3 February 2026

IEAPM Ref: 2026-02-L2

IEAPM Advice on Hunter Valley Operations Continuation Project (SSD-11826681 and SSD-11826621)

Figure 1 HVO Project Scope 1 Emissions Profile and Indicative Baselines²

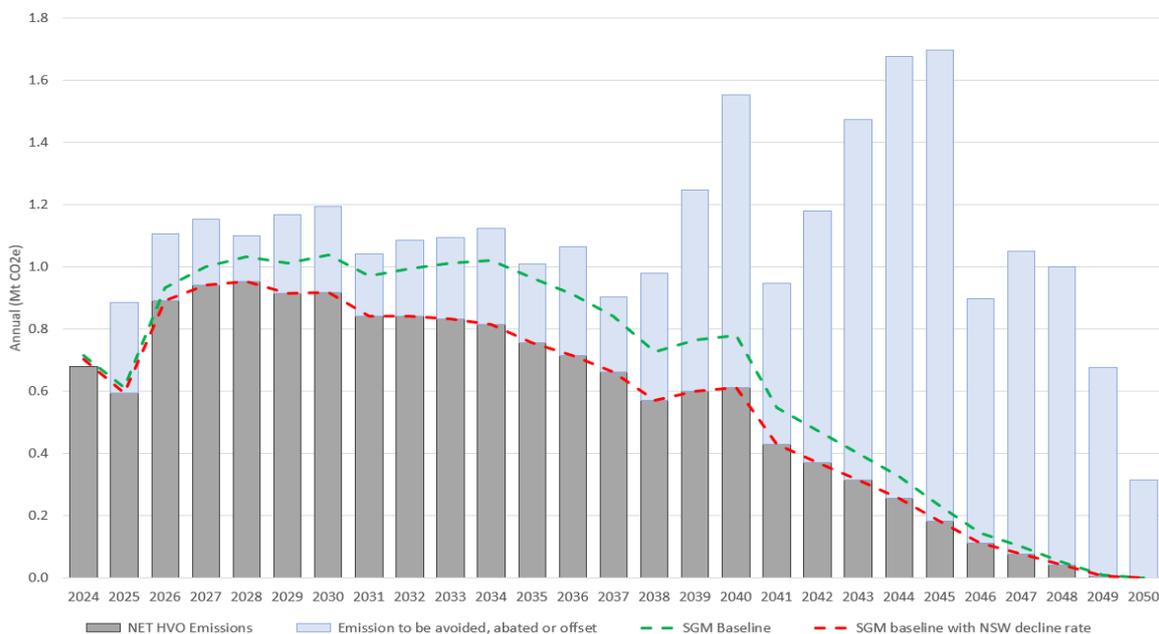
The Panel notes that mining in the higher gas zones of Domain 3 will occur in the period 2027 to 2029 (see Fig. 1 above), so *high priority needs to be given to the PFS*. In this regard, the Applicant should include in the PFS the proposed pathway and a schedule to potentially drain these higher gas zones.
